FW: LU/193/25/PL Courtwick Park

This is a significant change to the already revised drainage scheme with knock-on implications for landscaping/trees and I note the loss of the footpath. I have managed to agree that we will allow the review of this updated information and have sent it off, but I need you to provide updated site plans (site plan and boundary plots plan) that are coherent with the revised drainage scheme. Please note that this will be the last revision of the drainage details we will allow under this application.

Revised Drainage Strategy drawings attached with layout changes, revised drainage and revised levels.

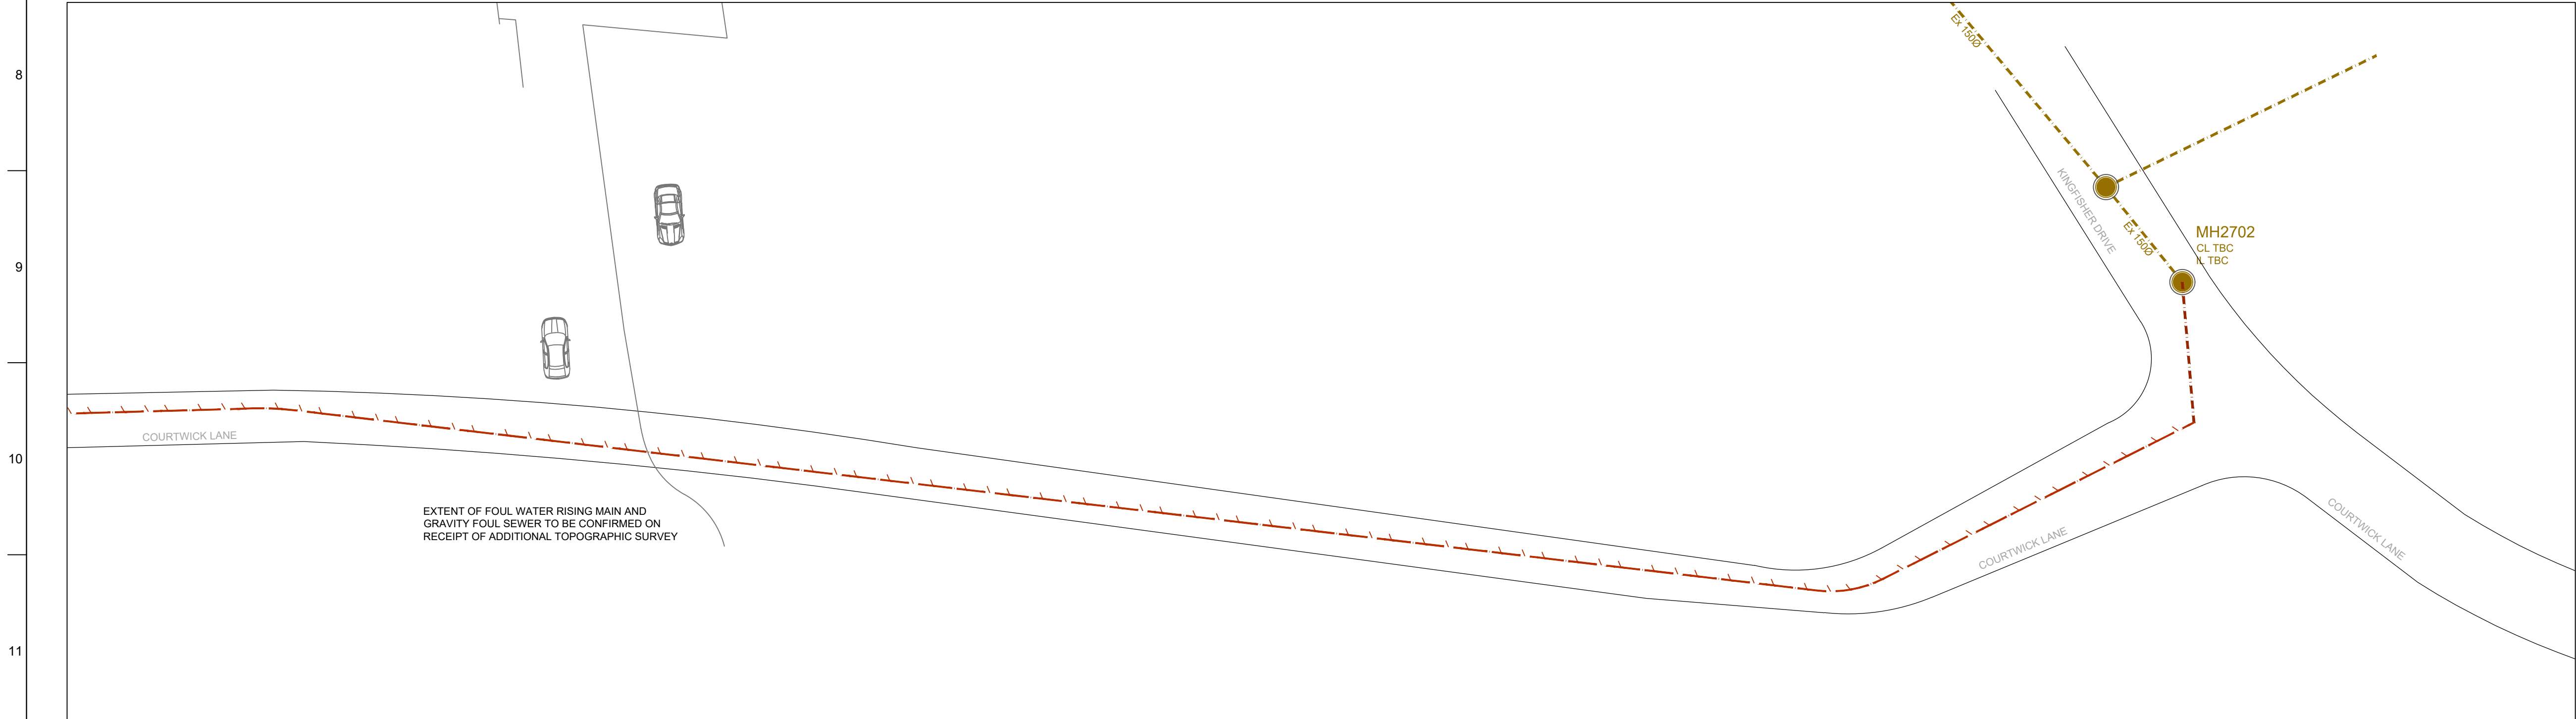
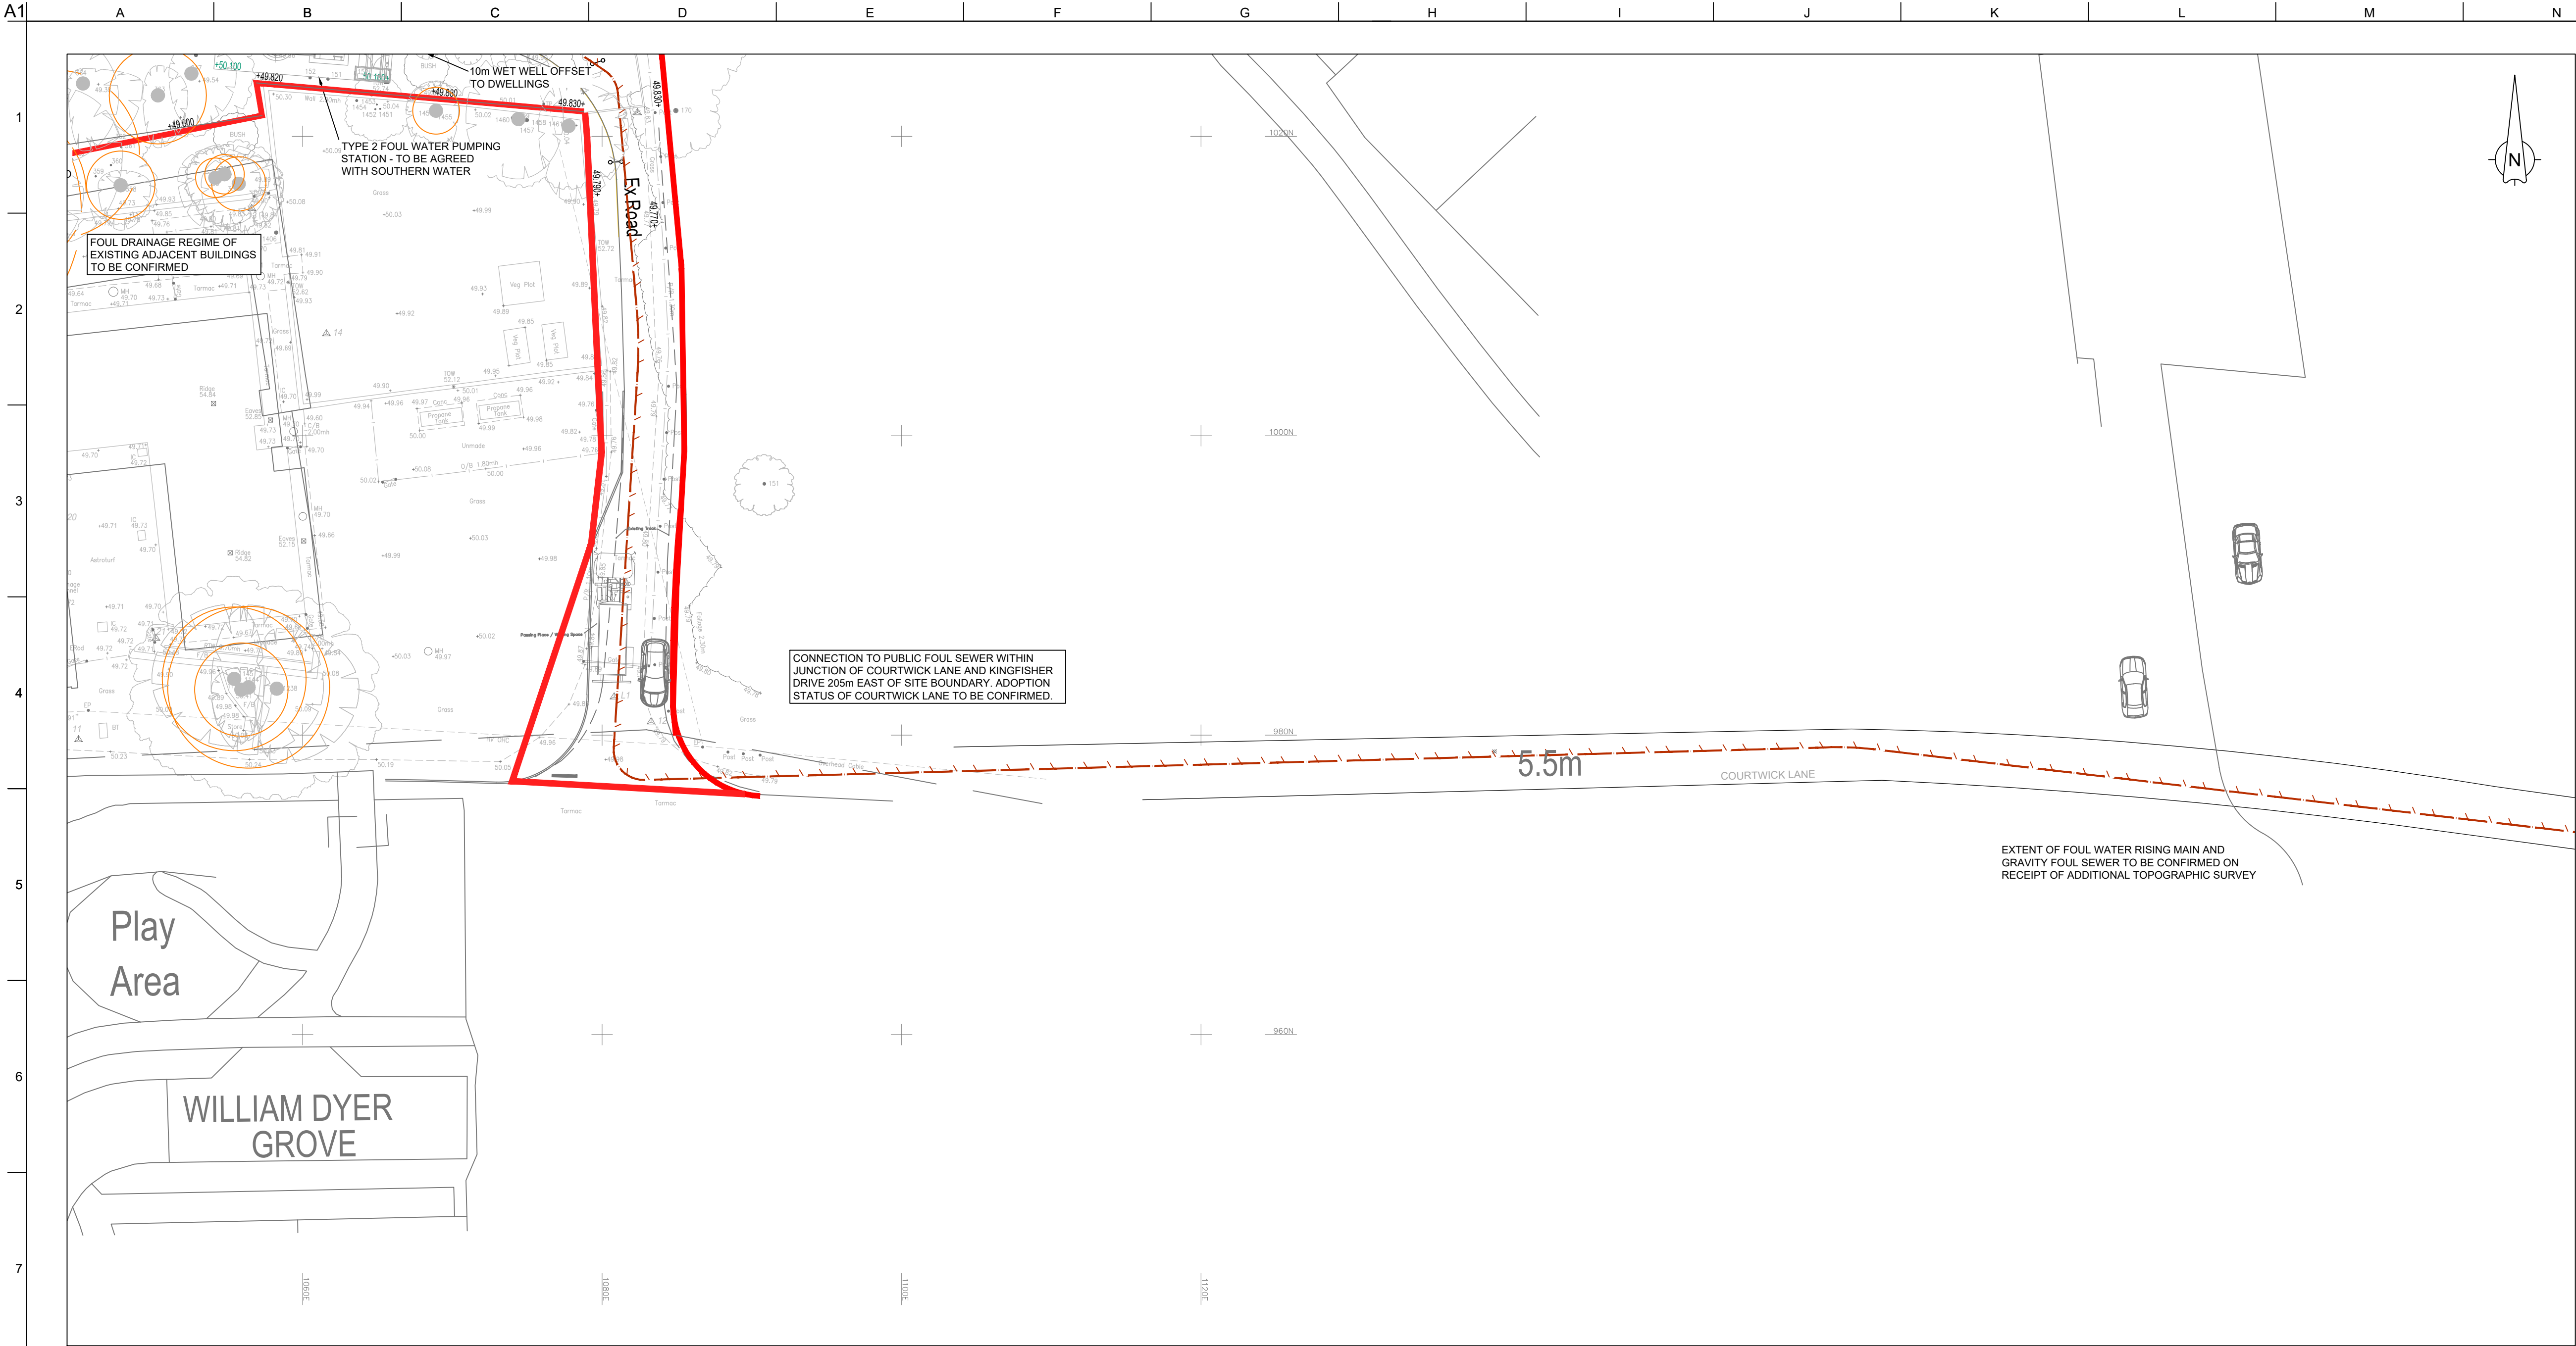
Separately, I note the overland flow modelling does not account for any positive drainage. Presumably, this applies to both the existing and proposed overland flood models. In the absence of our engineer's advice to the contrary, to me, the modelling appears to show the proposal would increase the extent and depths of flooding off site, which would be unacceptable. It does not result in the flooding of neighbouring buildings, but that is not the test. The NPPF does not differentiate between increasing the risk of flooding of buildings or other land off-site, it just states 'When determining any planning applications, local planning authorities should ensure that flood risk is not increased elsewhere'. We will need to see what our engineers have to say in respects of the submitted scheme once they have had time to review it.

- Footpath removed from northern edge of estate road to enable road to be pushed north, creating space for foul pumping station on the southern boundary.

- 0.575m wide (125mm kerb width, 400mm verge, 50mm wide pin kerb) hard paved verge added to southern edge of carriageway to provide an offset to the pumping station. Verge is splayed along the front edge of the pumping station so any maintenance vehicle can pull up close to the compound and vehicles can pass on the outside of the bend.

- Foul drainage route revised to suit.
- Road levels revised to get as close to existing levels as possible with consideration for tree route protection zones, notably the larger ones on the southern boundary which encroach within the road footprint.

- Plot 3 floor level reduce and retaining wall added to the rear to drop down to existing ground levels as quickly as possible off the back of the patio.

- Road 2 – turning head – levels drop at 1:20 towards the low spot to the south.
